DRB CASE ACTION LOG

DRB Application No.: 03-01549 (SPS) 03-01550 (SBP)

Project # 1002716

Project Name: NO.ALBQ.ACRES TR A UNIT A

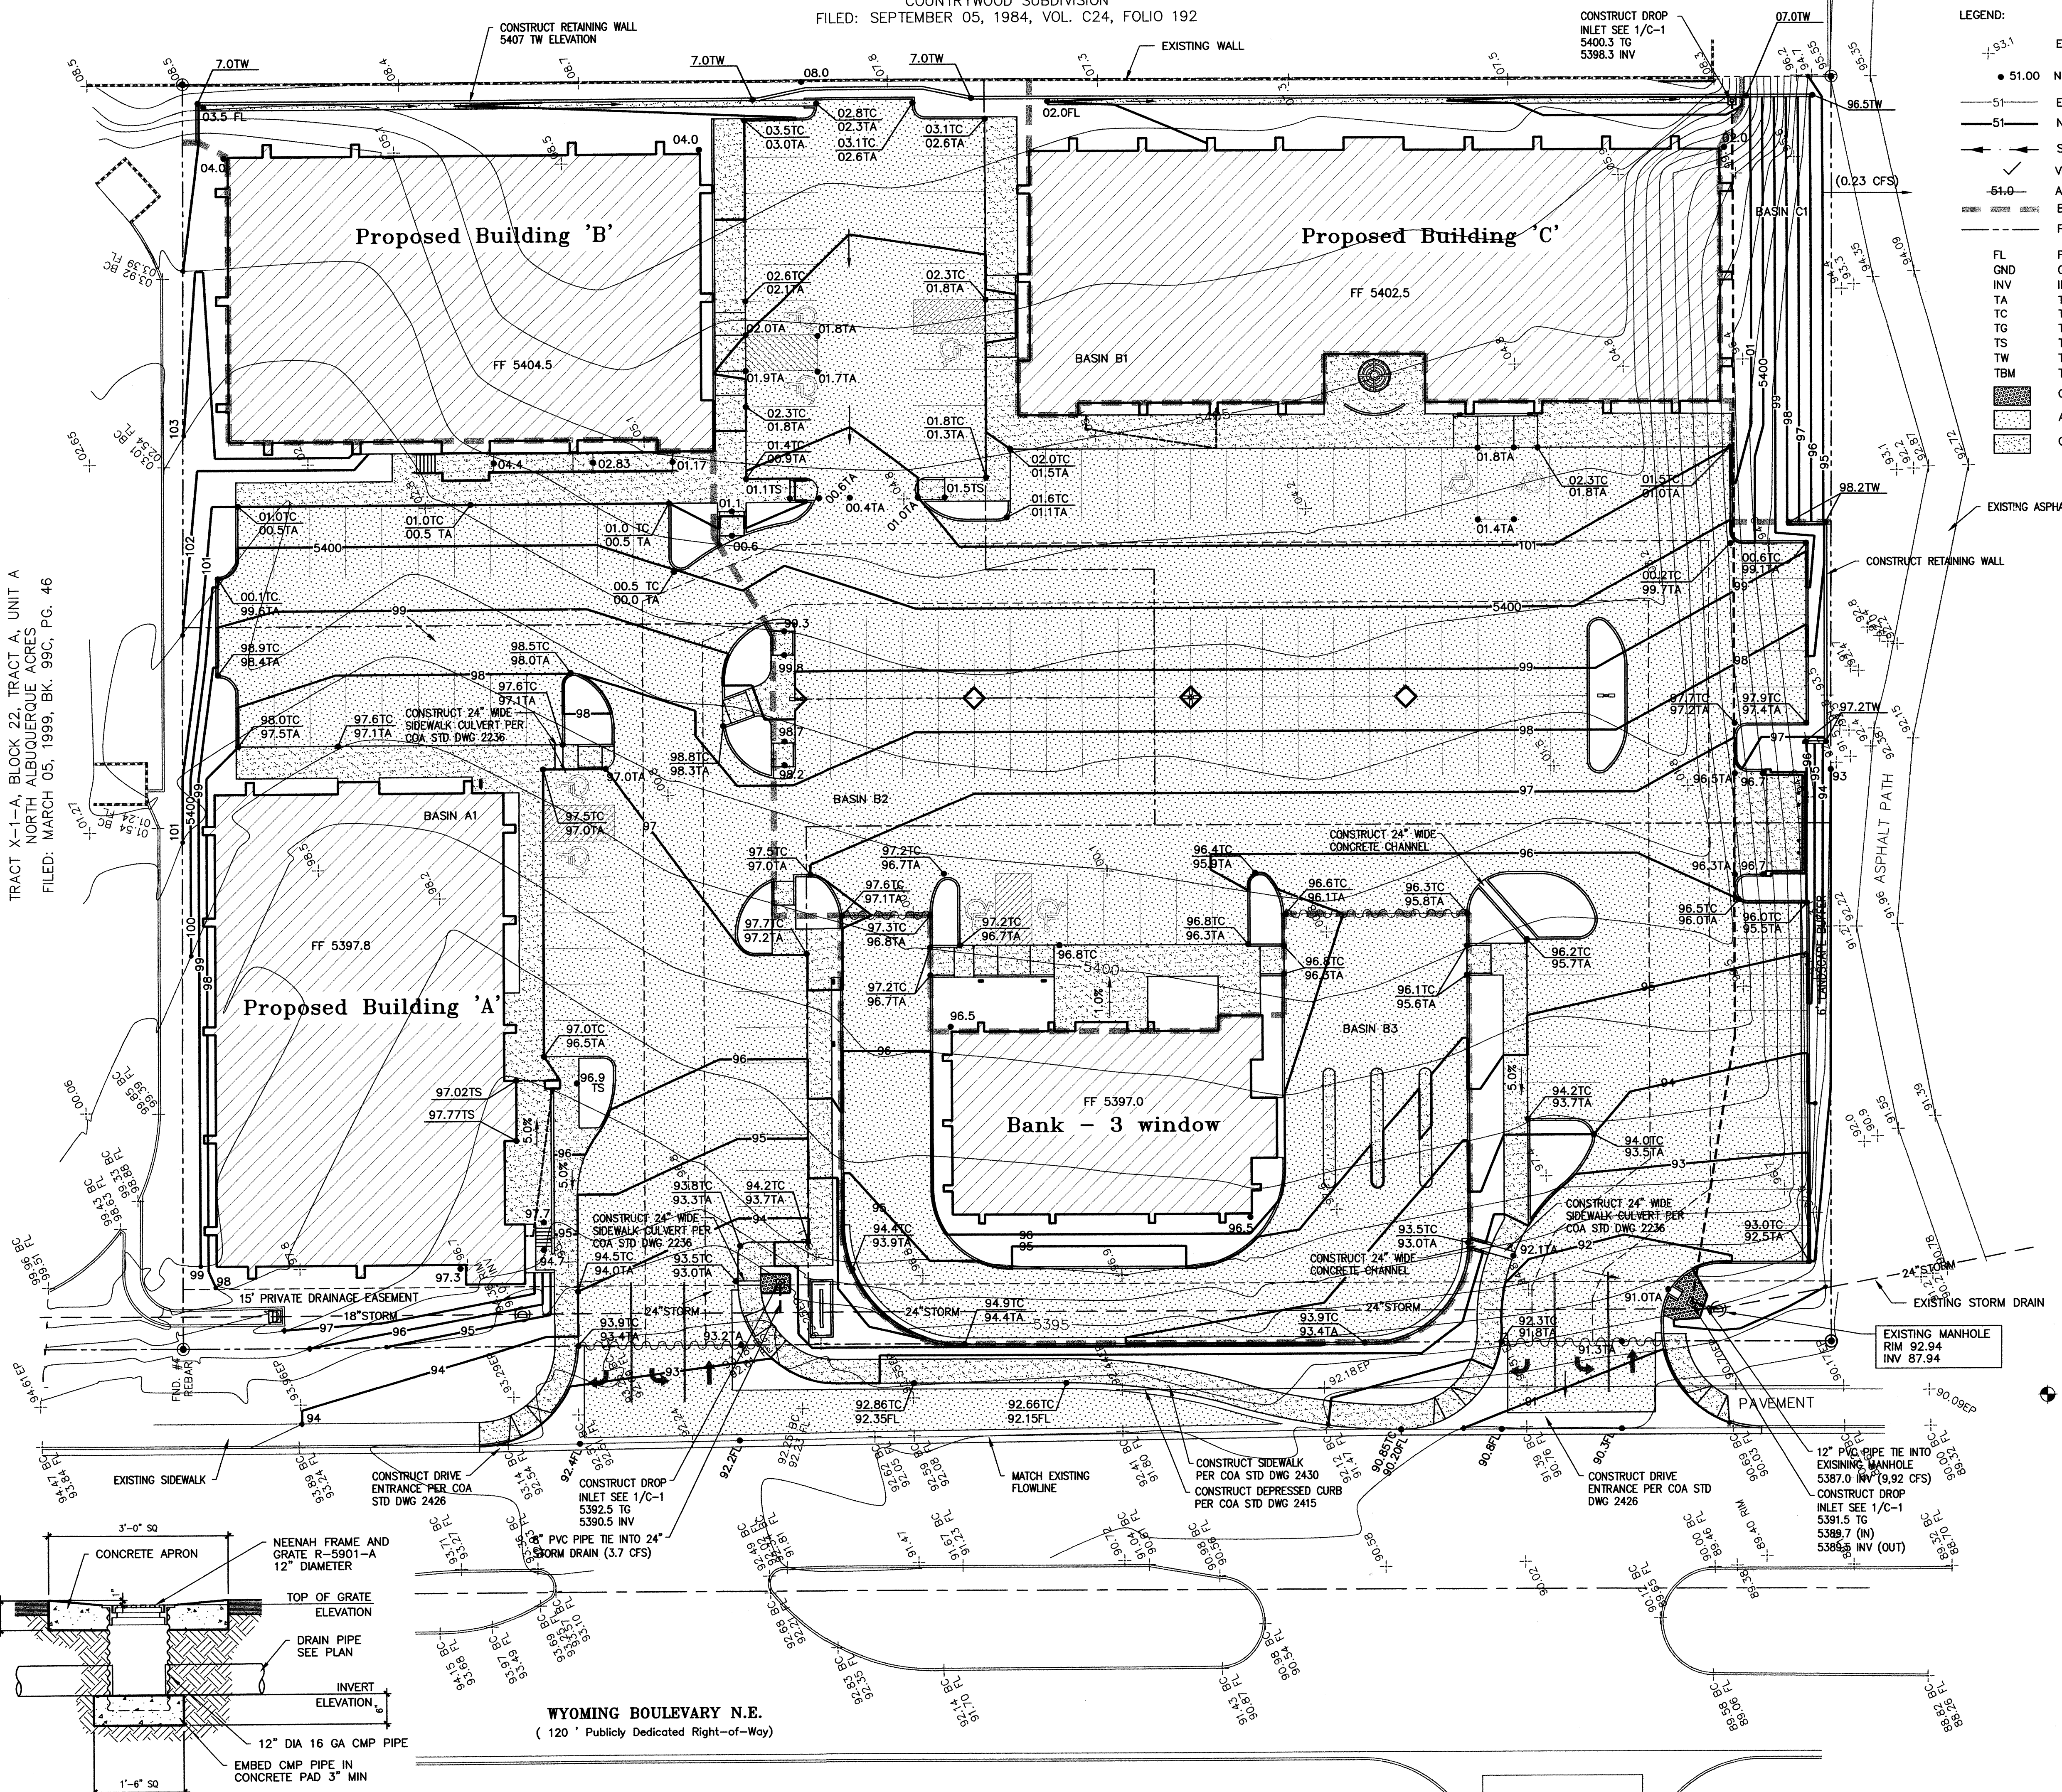
- TRANSPORTATION: _____
- _____
- _____
- _____
- _____
- UTILITIES: Plat must match Site Plans for Utility Easements and proper Dedication/Maintenance statement

- _____
- _____
- _____
- CITY ENGINEER / AMAFCA: _____
- M to B of pvt esmt
- Dedicate Public Access As R/W
- Document the site plan on the Private Access note.

The plat does not match the site plan.

SHEET SP-1

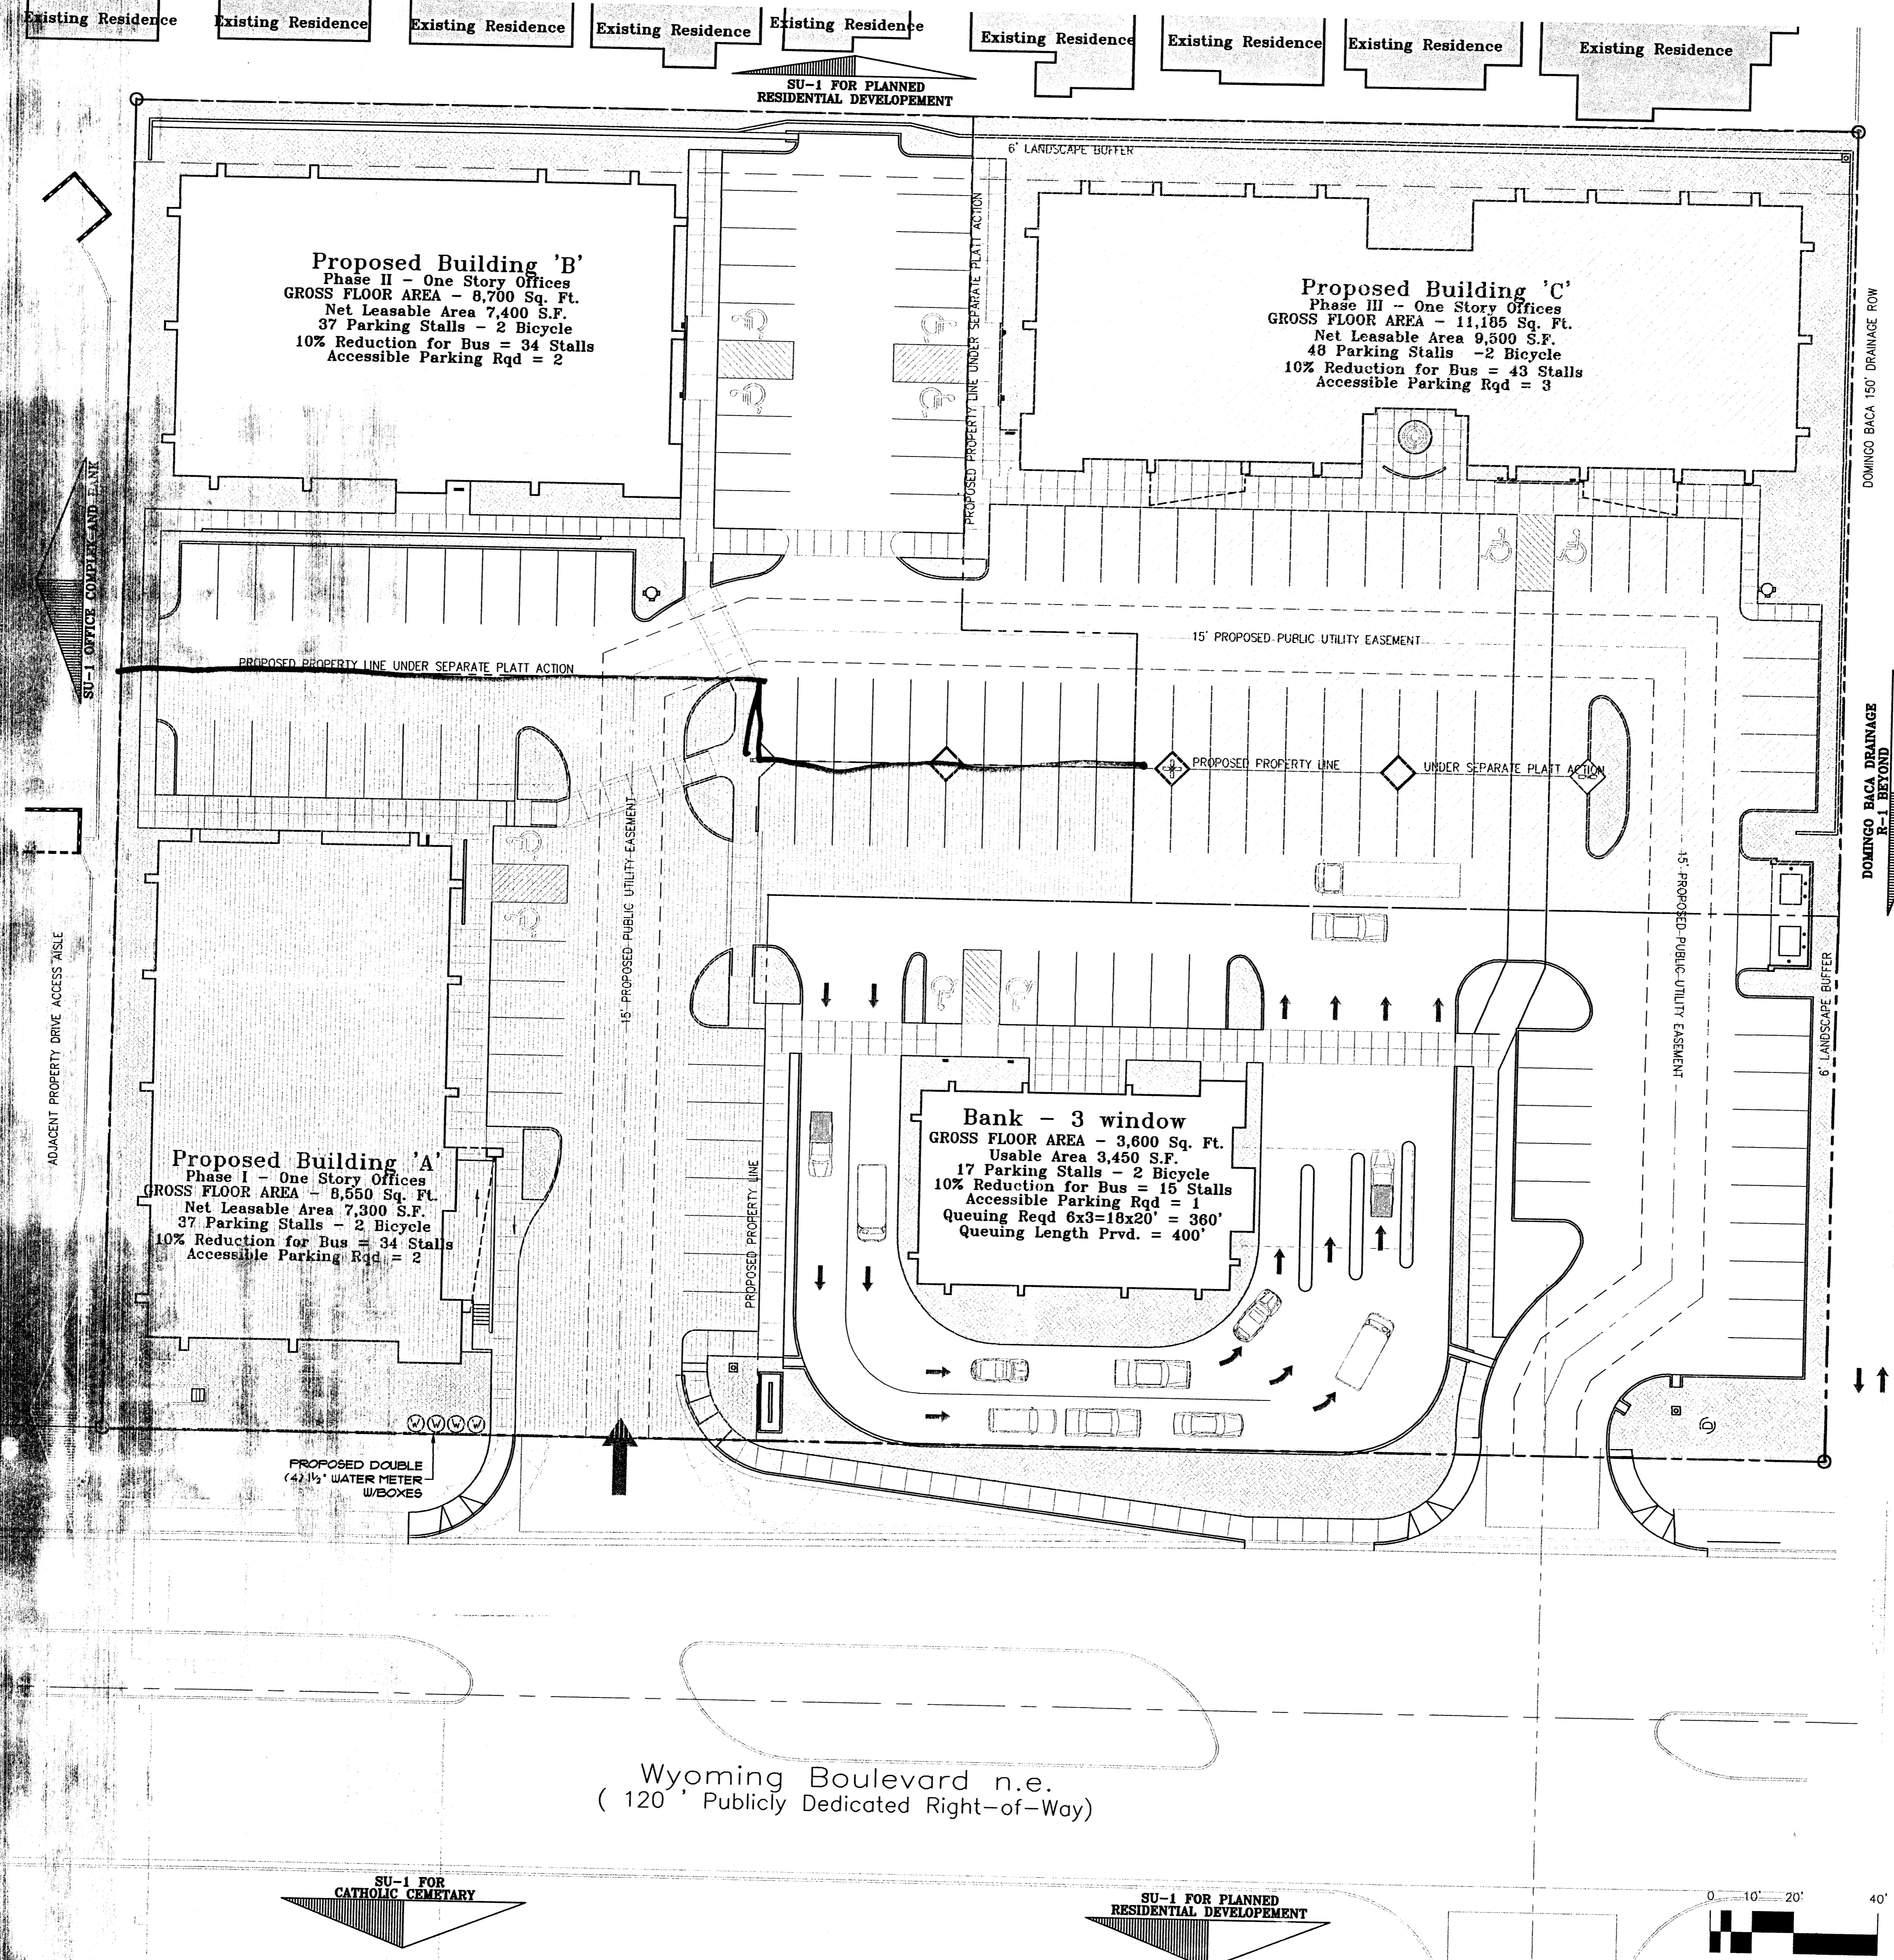
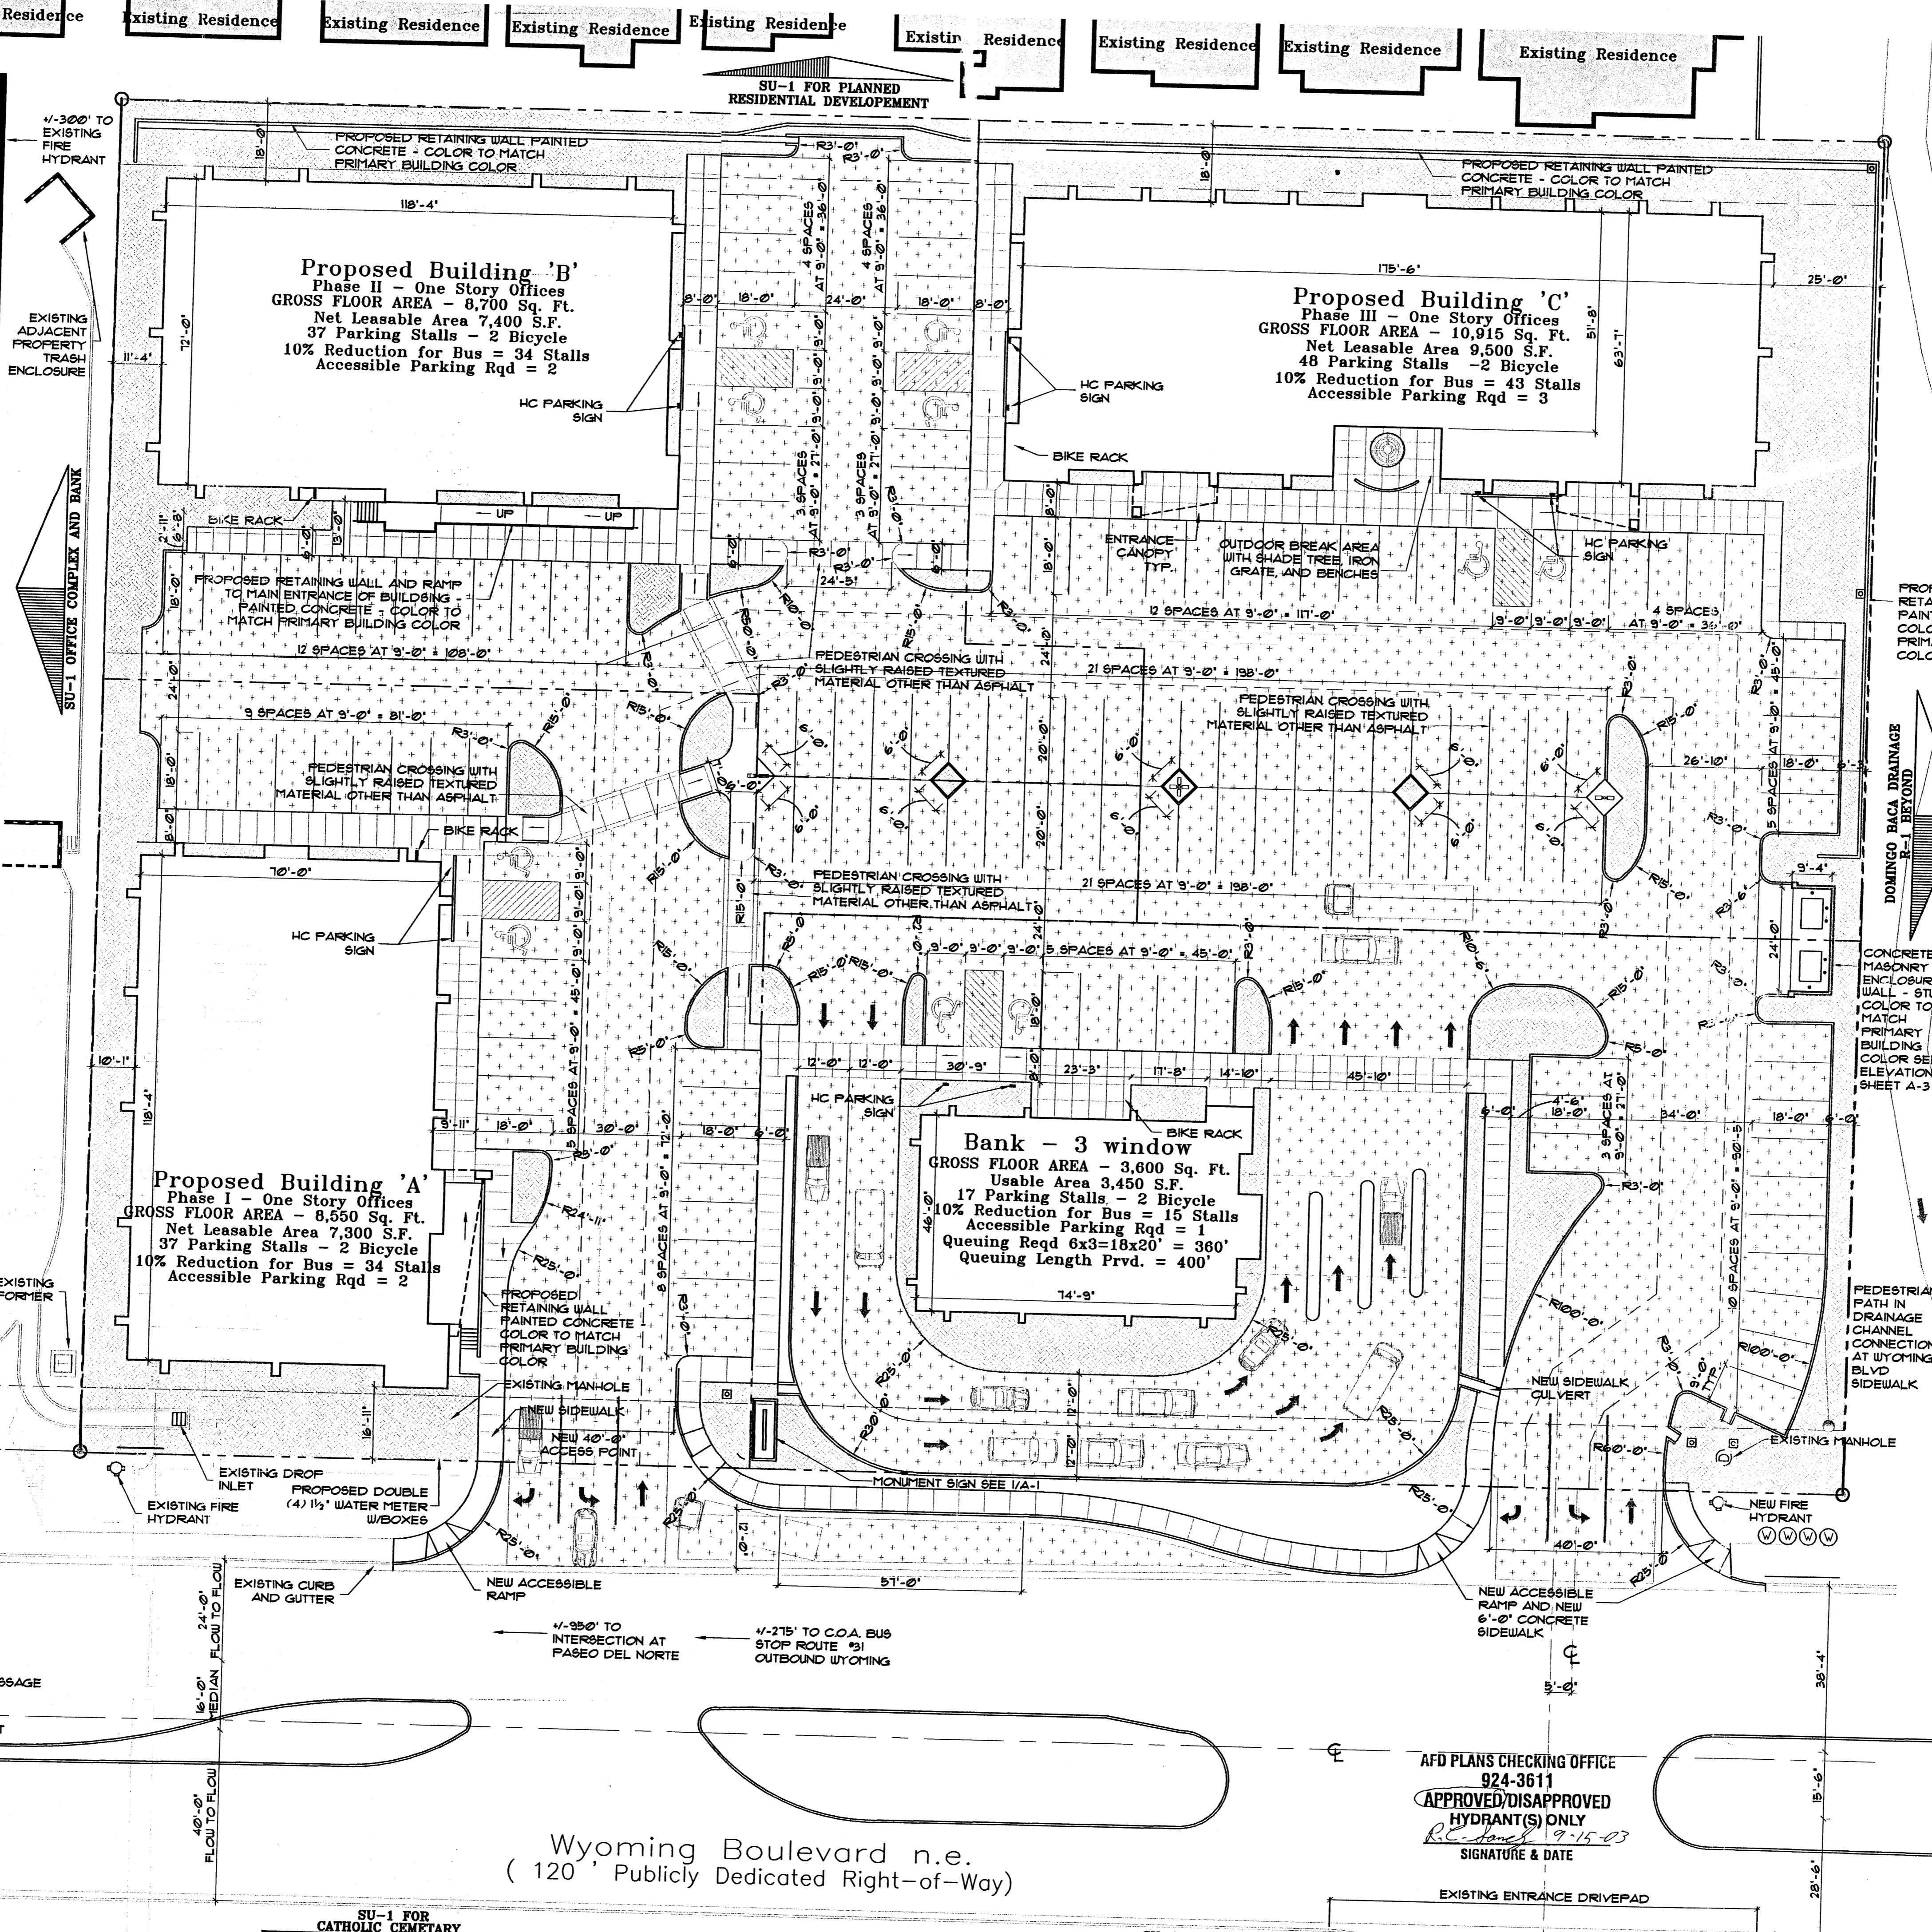
UTILITIES: Site Plan Utility layout (water/sewer/fireline)
 must match Plat Easements
